**From:** Contact Centre (CRM) <contact@ribblevalley.gov.uk>  
**Sent:** 19 April 2022 11:42  
**To:** Planning  
**Subject:** Planning Application Comments - 3/2022/0105

**Planning Application Reference No.:** 3/2022/0105

**Address of Development:** 1-5 Back St Pauls Street Low Moor Clitheroe BB7 2LS

Drawing No: **DWG/01** Revision: **C 21st November 2017**

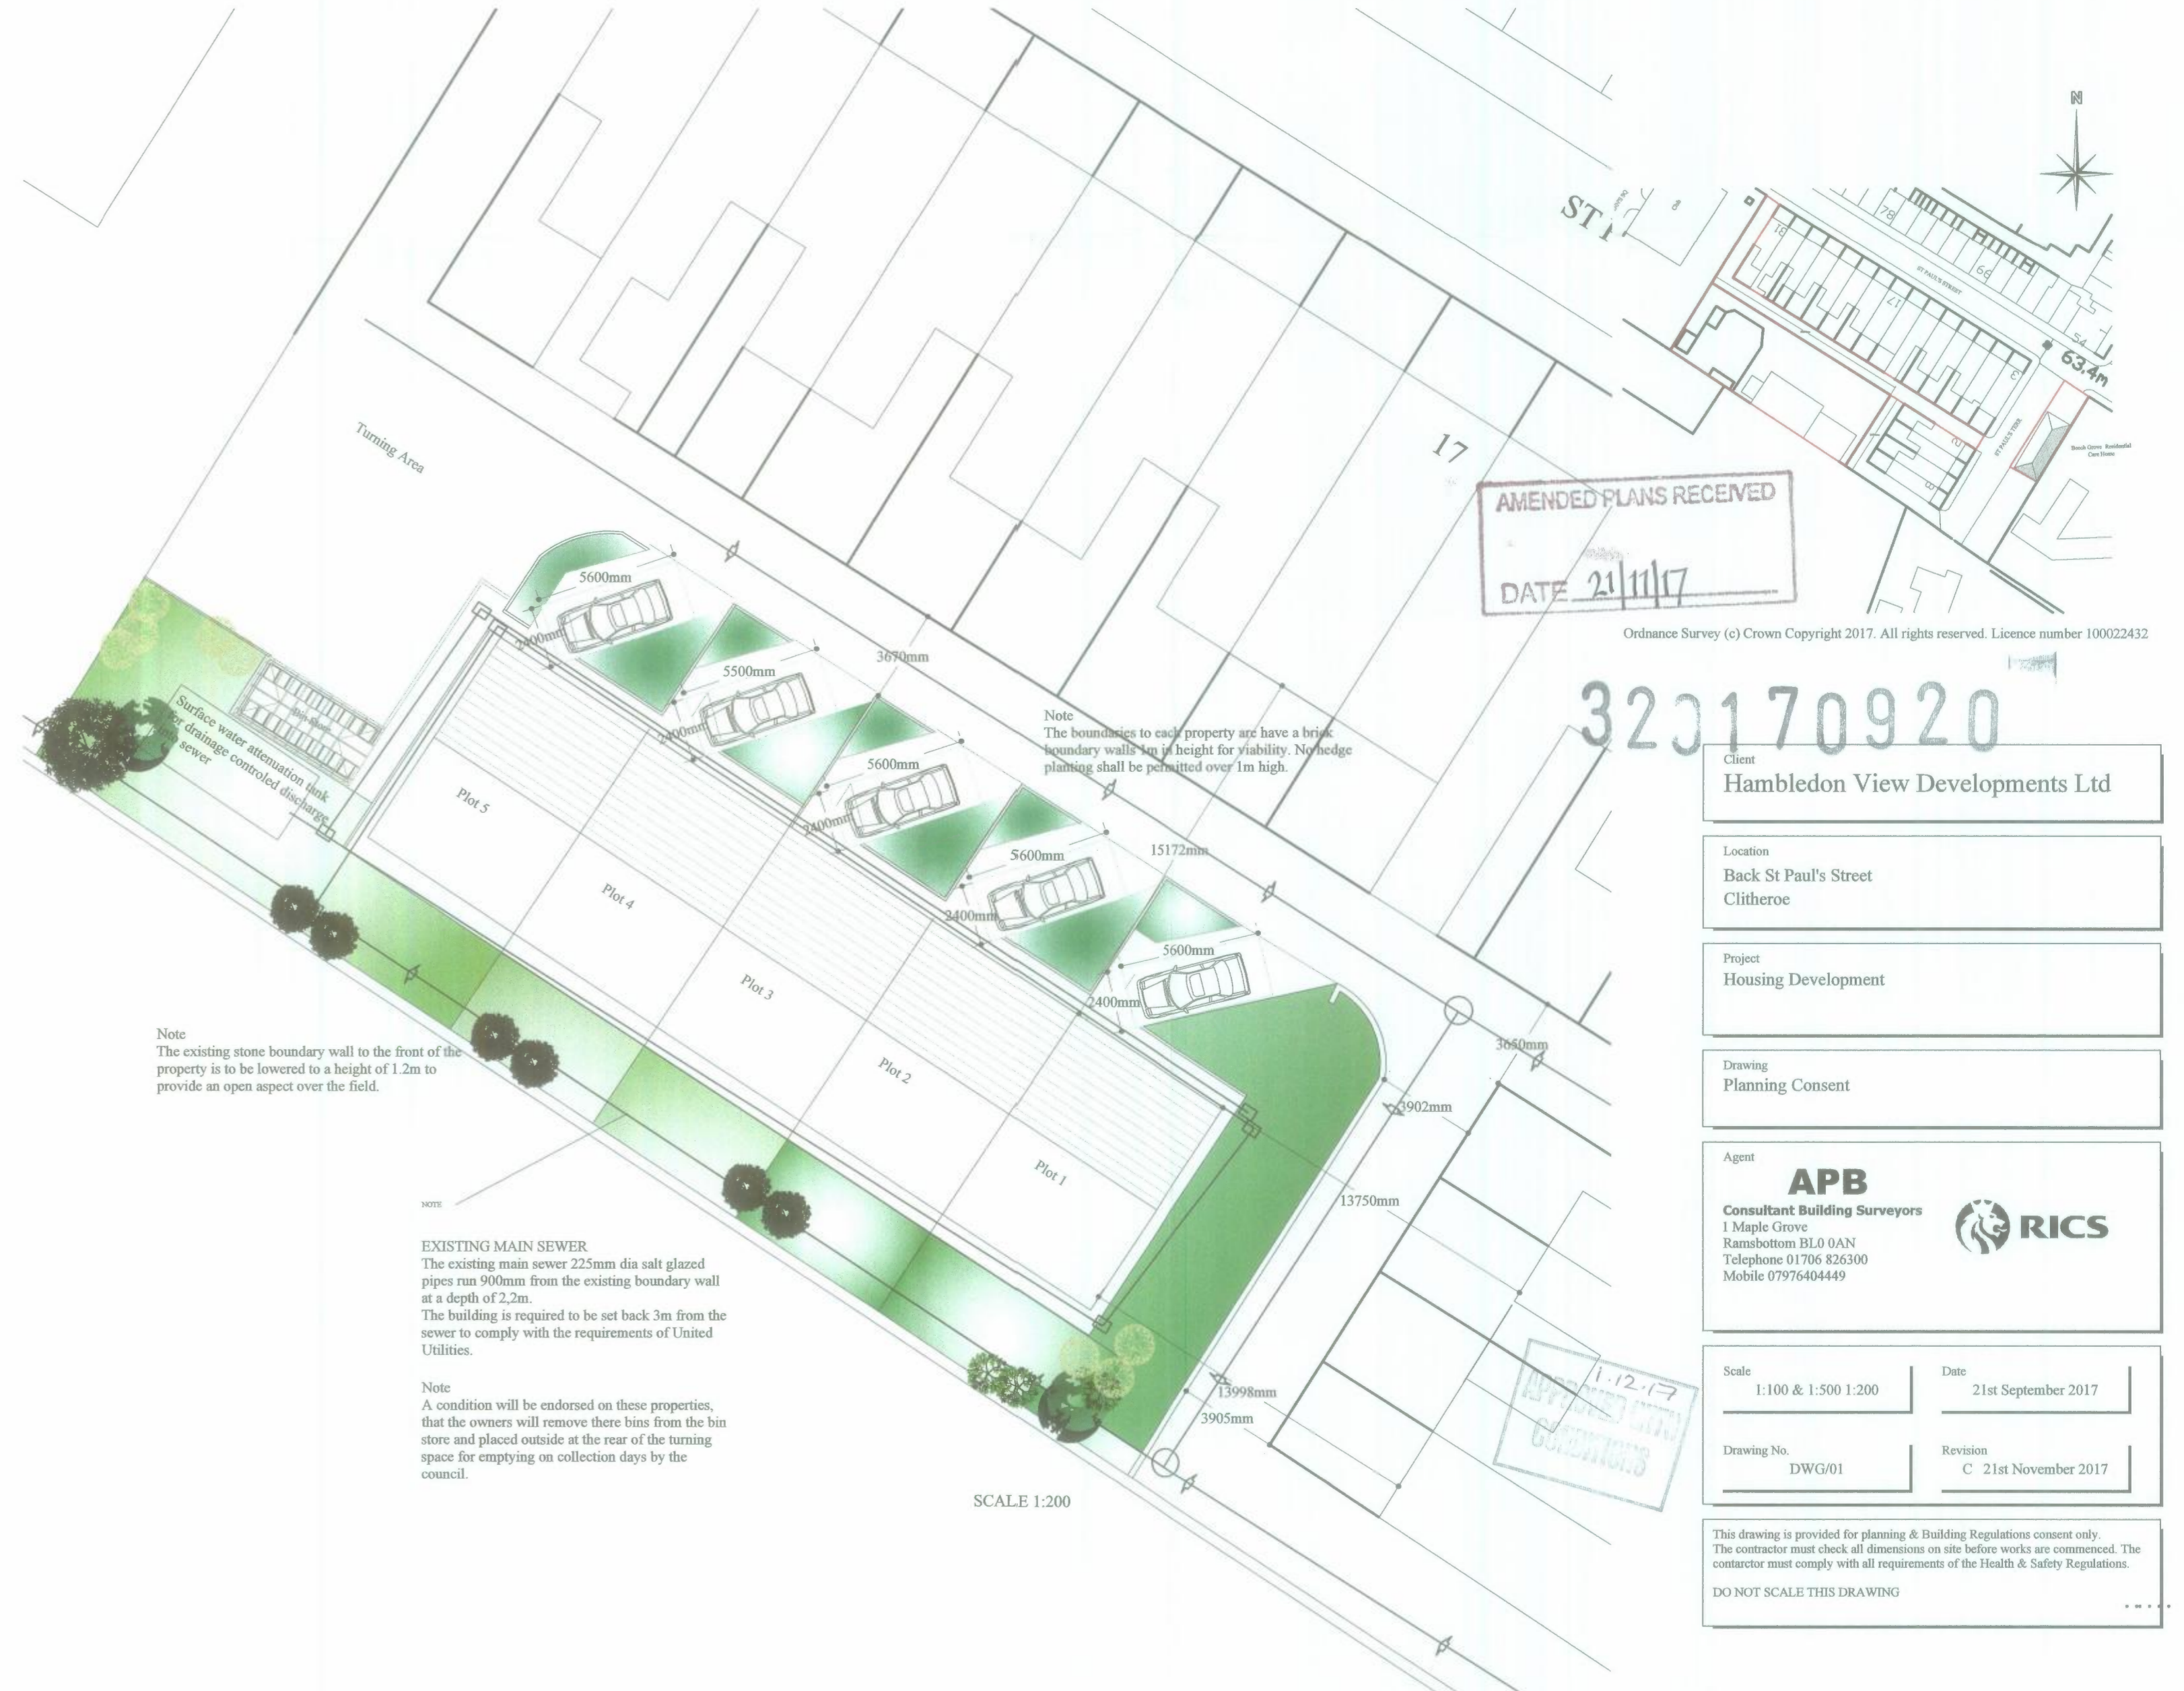
The turning head approved as part of the original application was of a suitable size to accommodate all vehicles

visiting the site and would therefore mitigate for the substandard access and parking arrangements and eliminate the need for any reversing manoeuvres along the access road. This is highlighted below in an extract from the original officer's report for application 3/2017/0920:

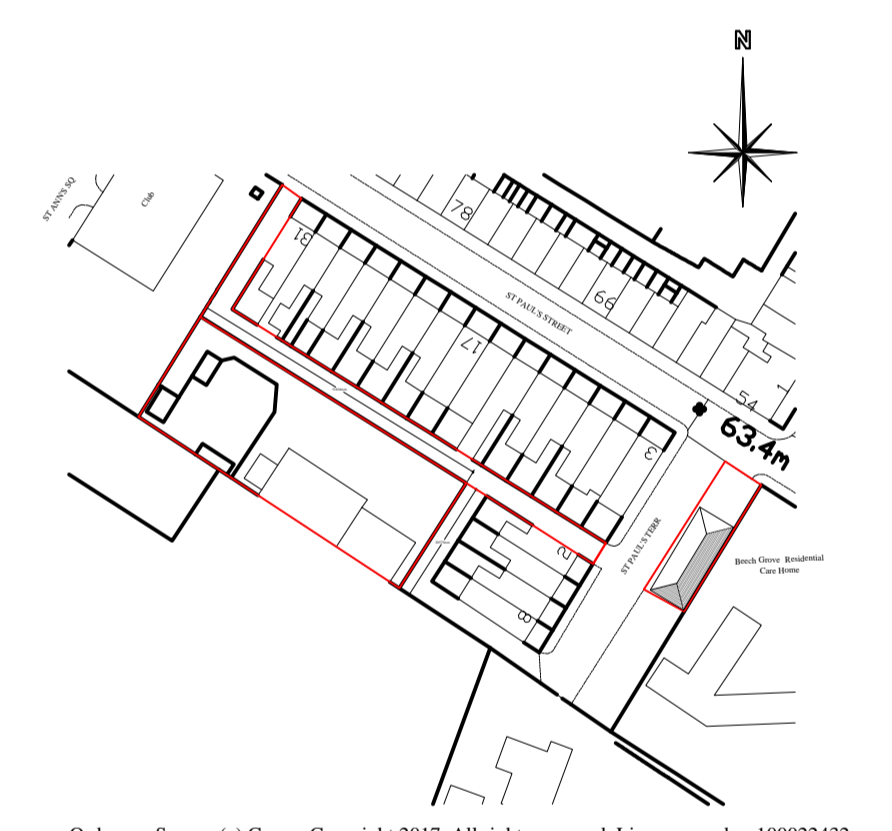
The turning head now proposed (and already constructed) as part of this application is of a smaller scale than approved. It would not allow the vehicle manoeuvres that are indicated on the submitted drawings. As highlighted above the adopted access road is only 3.6m wide and the proposed turning head cannot accommodate any vehicle bigger than a small car. This makes it unsuitable for the majority of vehicles accessing the site, resulting in them having to reverse along the full length of the access road and then onto St Pauls Terrace, without safely being able to see. This would include delivery vehicles such as courier and supermarket delivery vans and most family sized cars.

Can we also highlight that the submitted drawing (DWG/site/01B rev A1) as part of this application is technically incorrect. It states the new turning head is 4333mm x 8095mm. The turning head already constructed is 4700mm x 7000mm.

A 1.8m high wooden fence has also been constructed around the turning head . The height of this existing fence impacts on the available sightlines from both the turning head and the driveway for plot 5. As approved in application 3/2017/0920 all walls along the site's frontage should be no more than 1m in height.

As part of the original application the new dwellings were to have their bins emptied within the new turning area.

A workable strategy needs to be agreed to manage refuse collection. If the current situation is not addressed highway safety will be compromised and access to the site will be restricted on collection days .
